# STERLING RANCH FILING NO. 2 -STERLING RANCH ROAD BETWEEN MARKSHEFFEL ROAD - DINES BLVD

## STREET IMPROVEMENT PLANS

**Engineering Review**  
07/28/2020 1:01:18 PM  
Jsdrice  
JeffRice@elpasoco.com  
(719) 520-7877  
EPC Planning & Community  
Development Department  
**See comment letter also.**

CDR-20-005

STERLING RANCH - VOLLMER ROAD CROSS SECTIONS

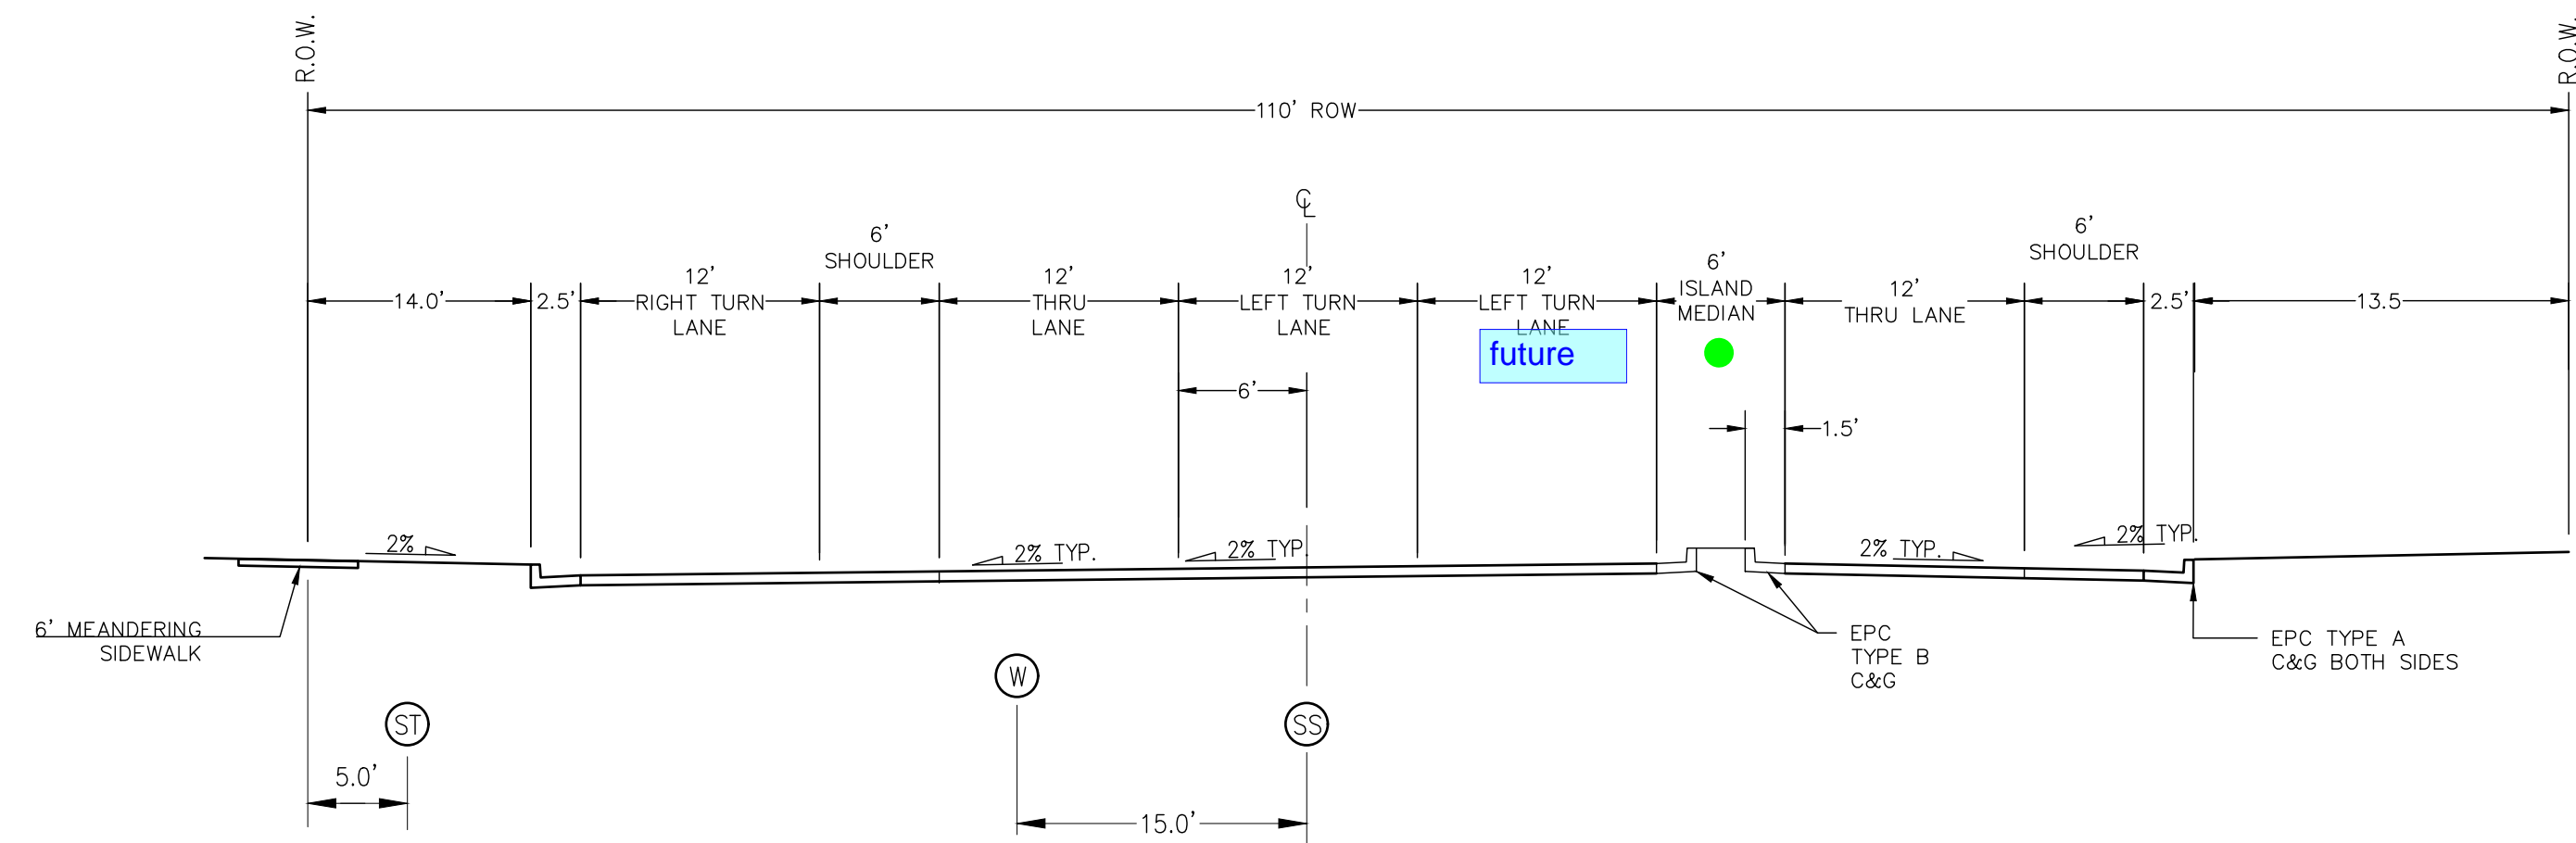
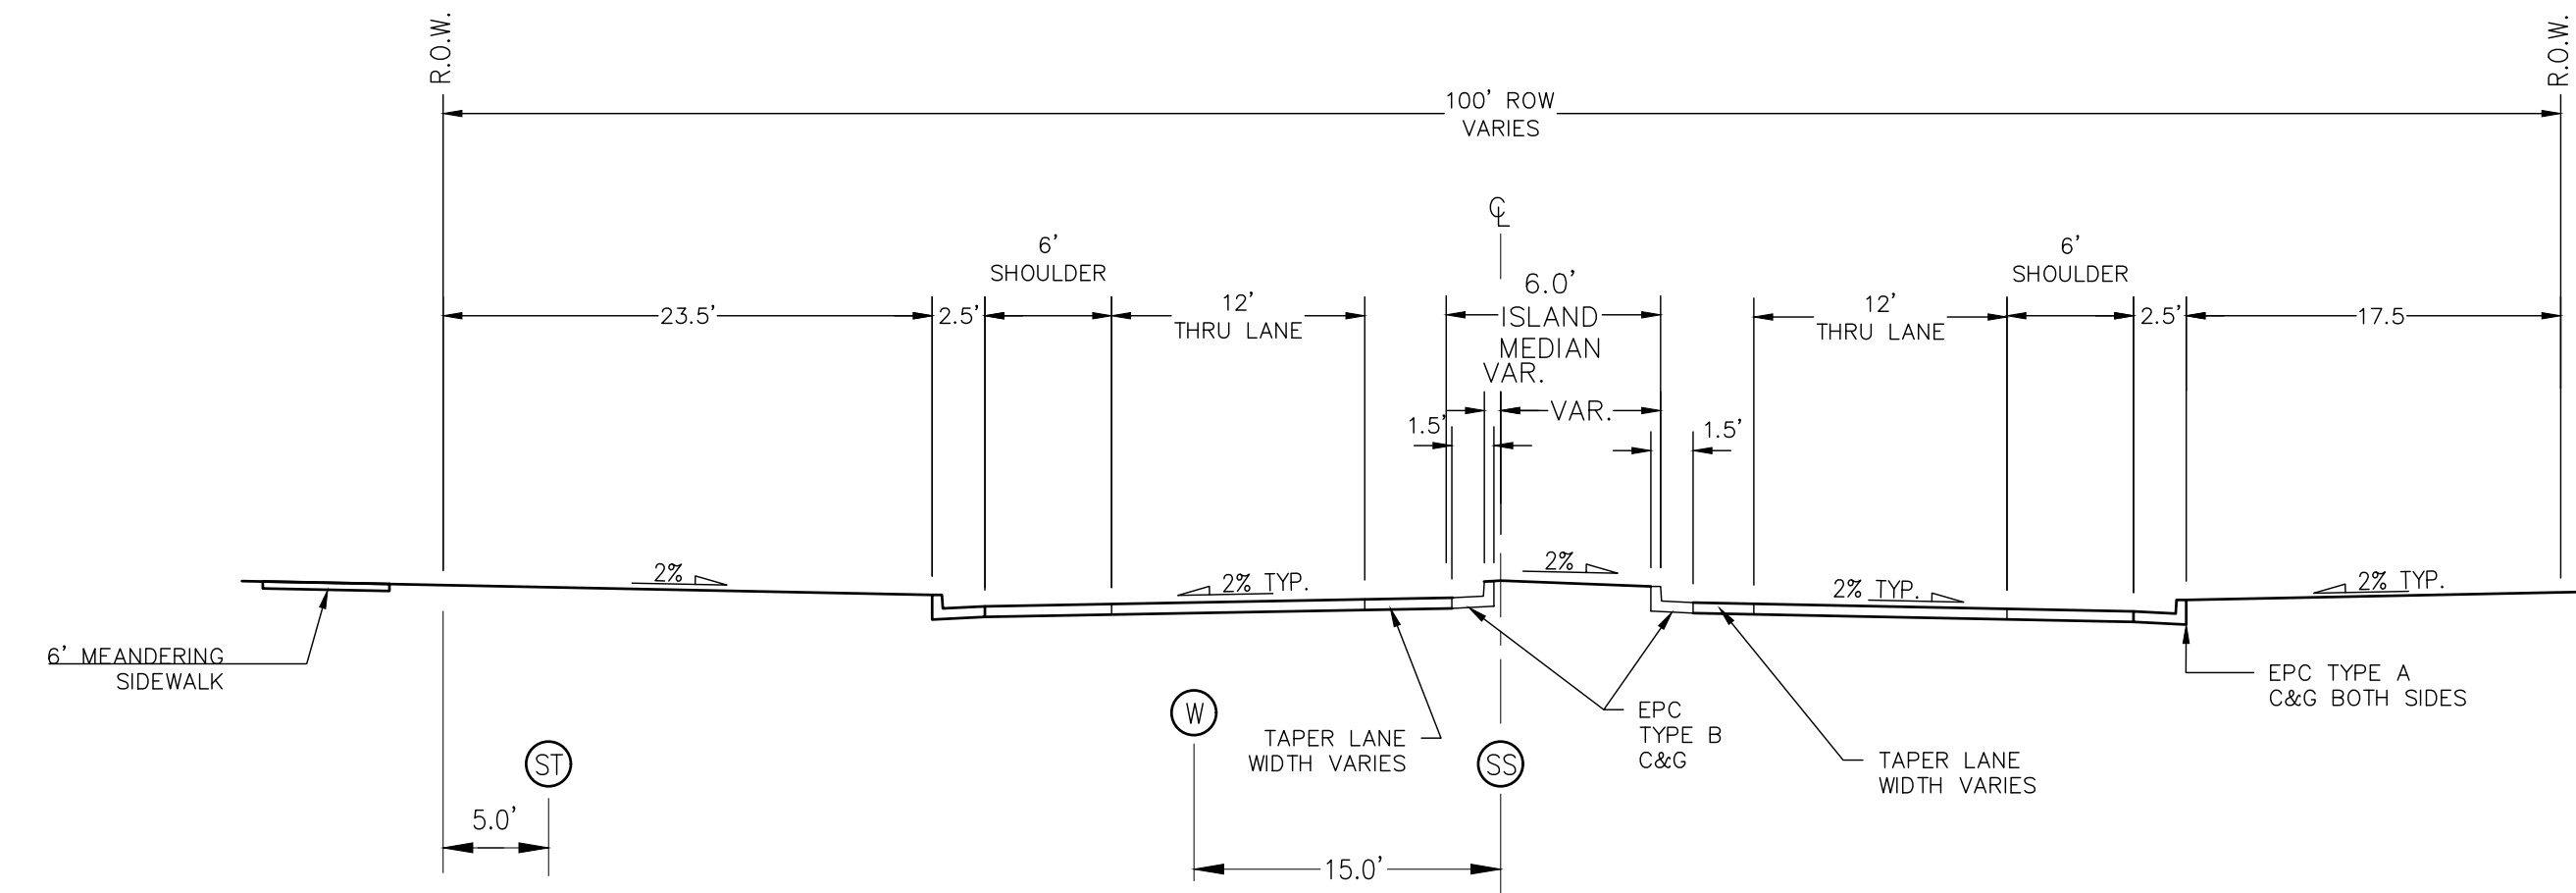
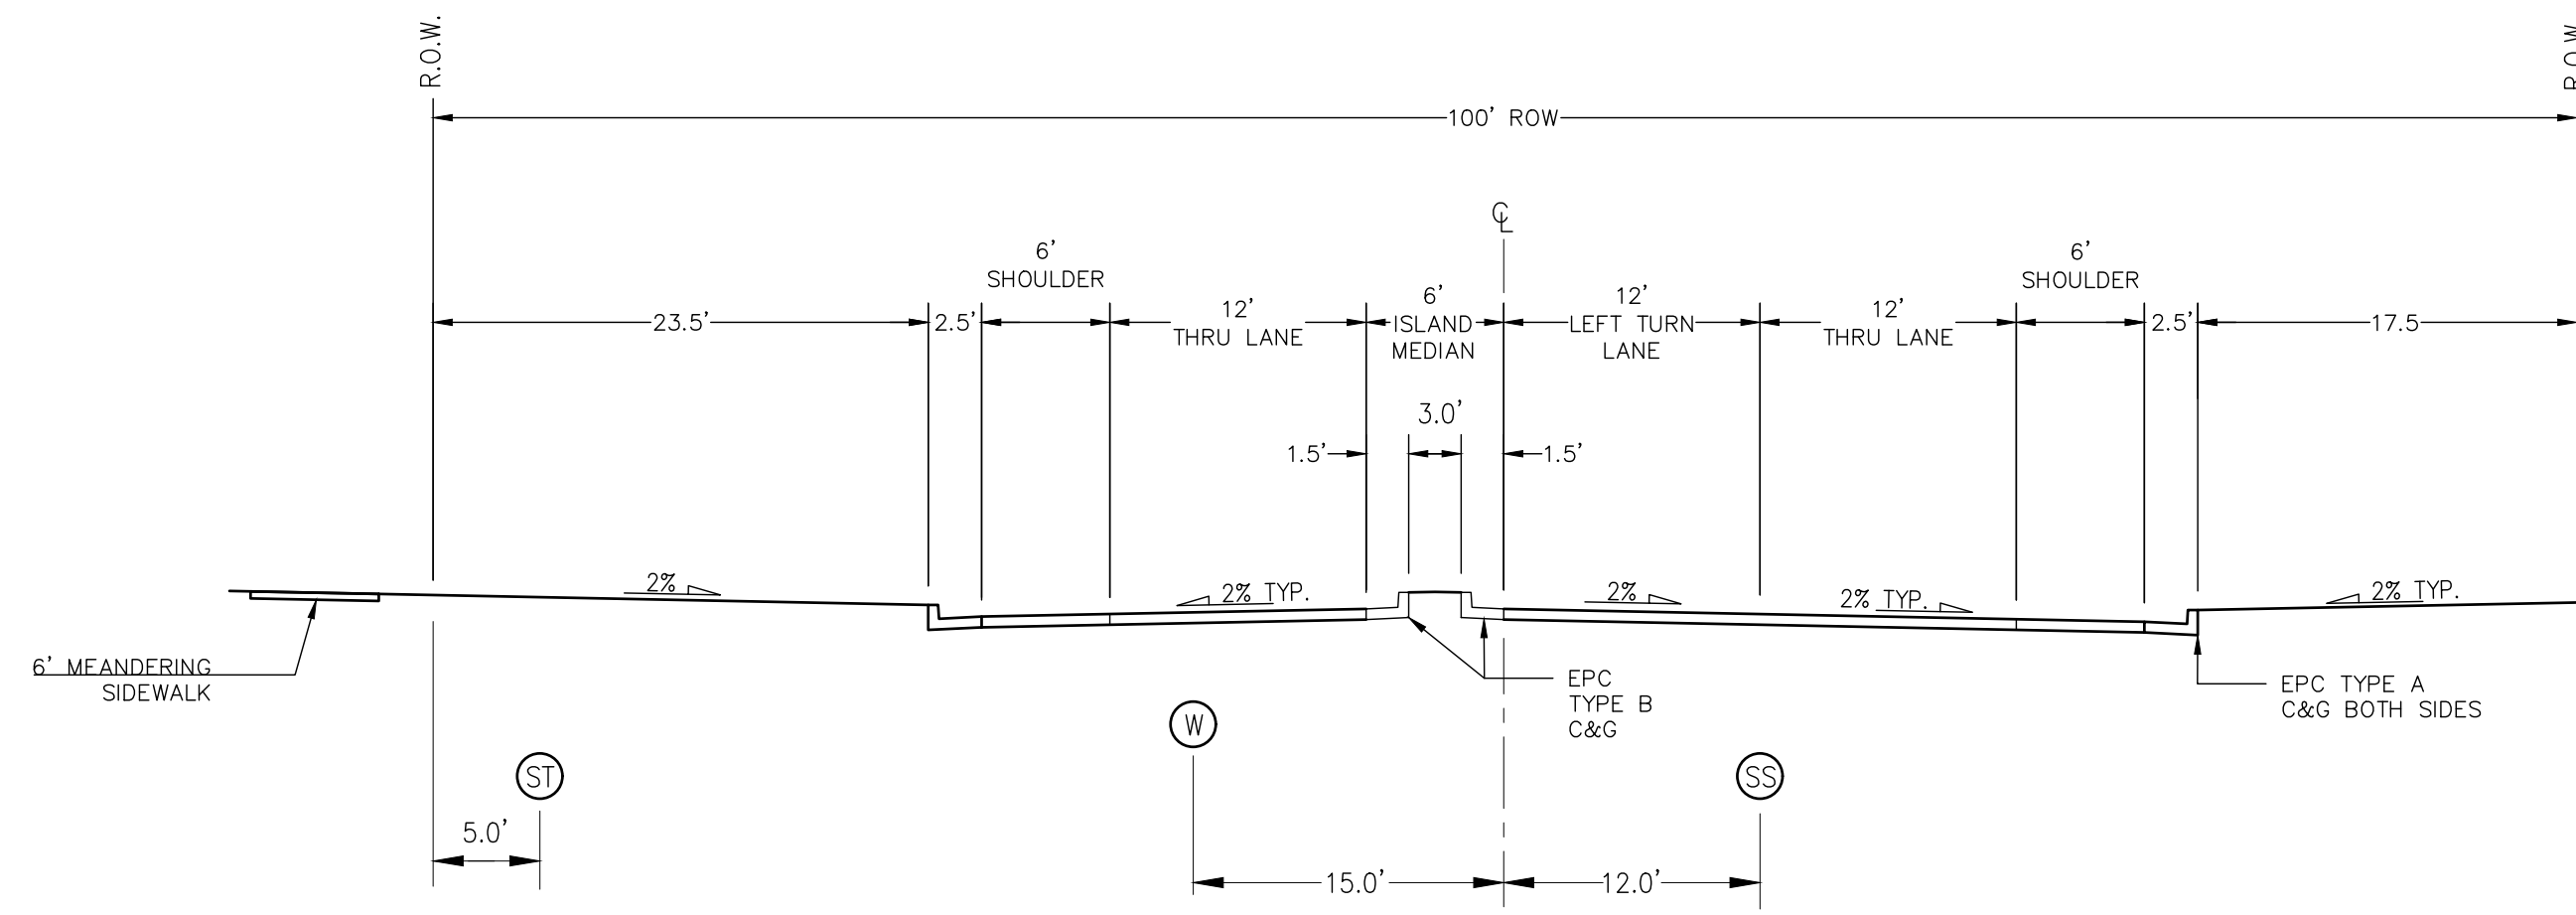
doesn't match preliminary plan

**STERLING RANCH ROAD
STA 12+50.00 TO 24+79.37**

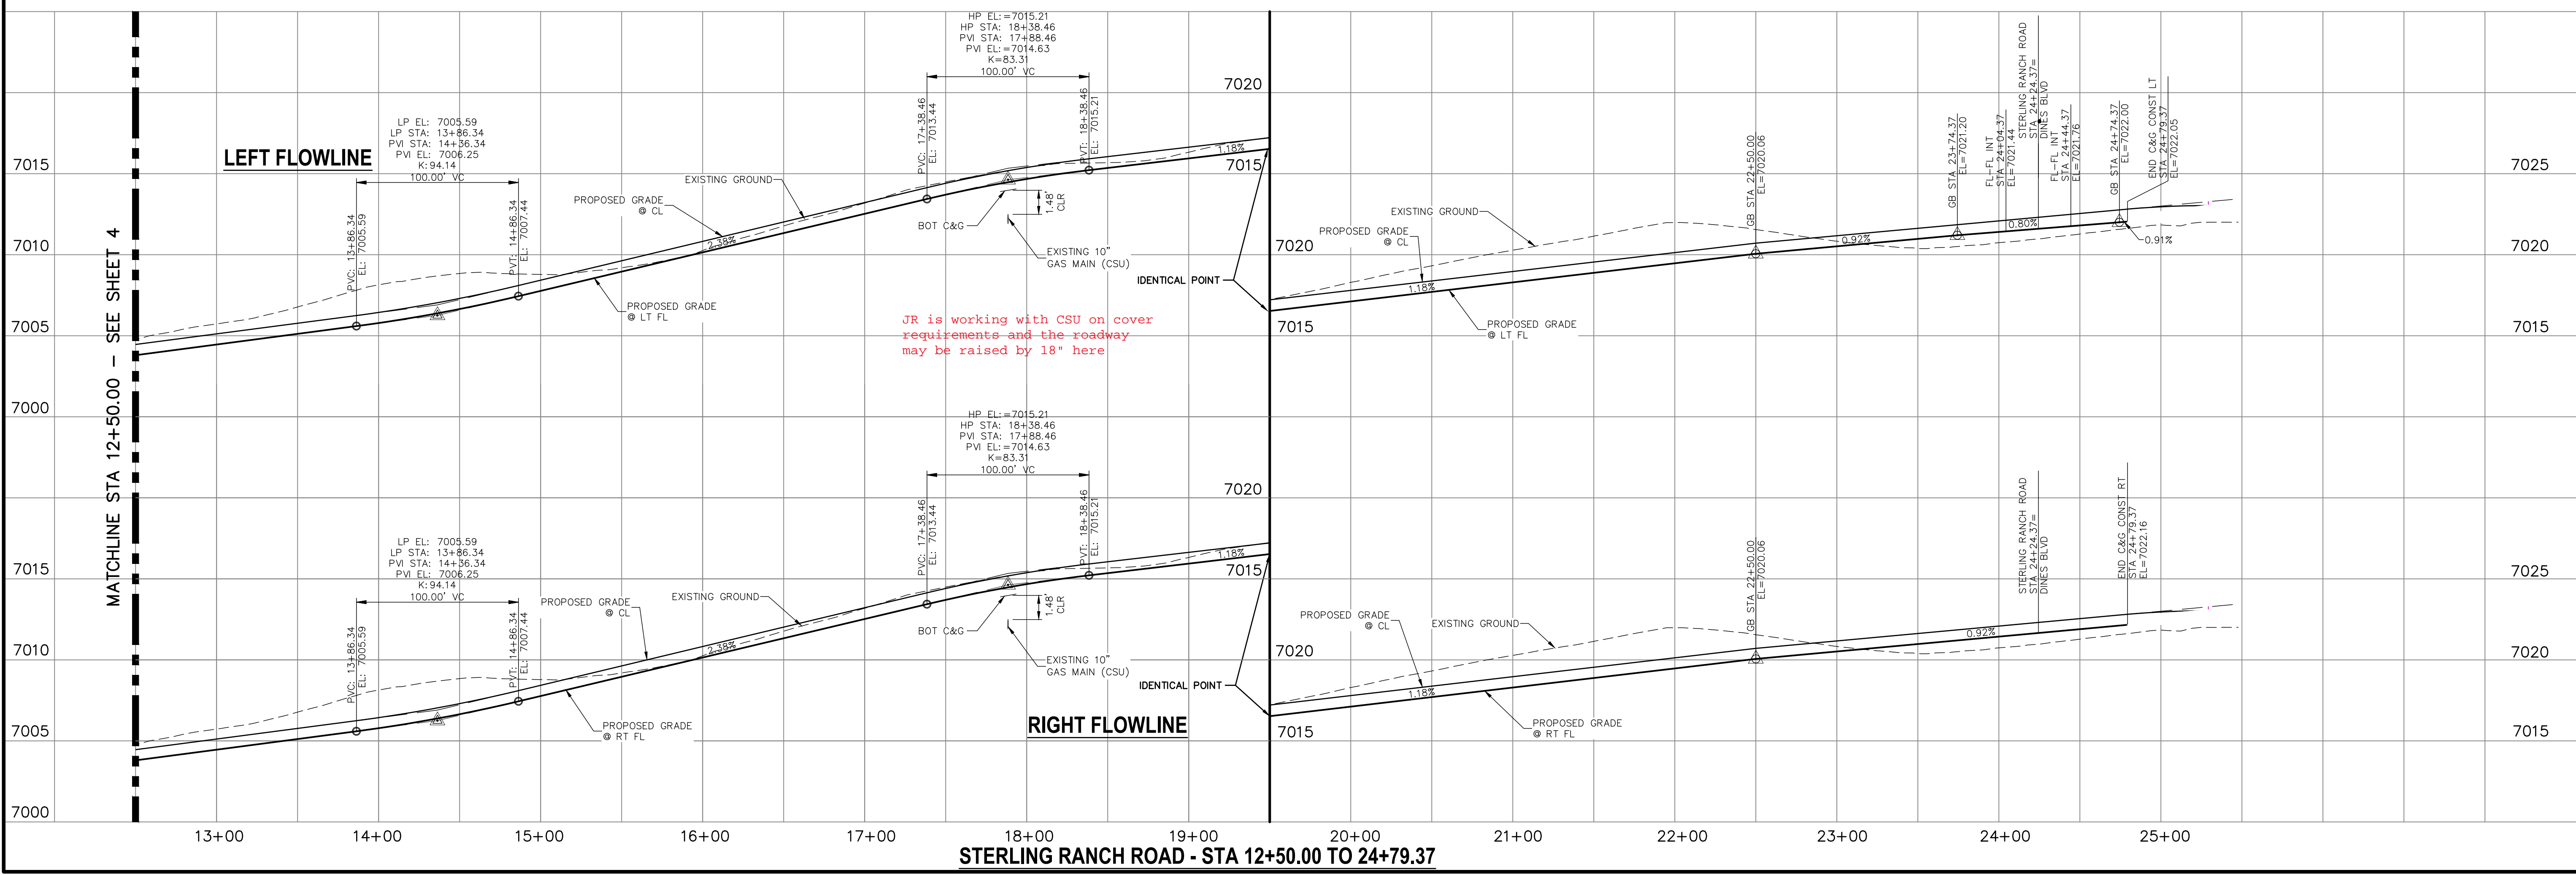
APPROVED FOR WATER REVISION
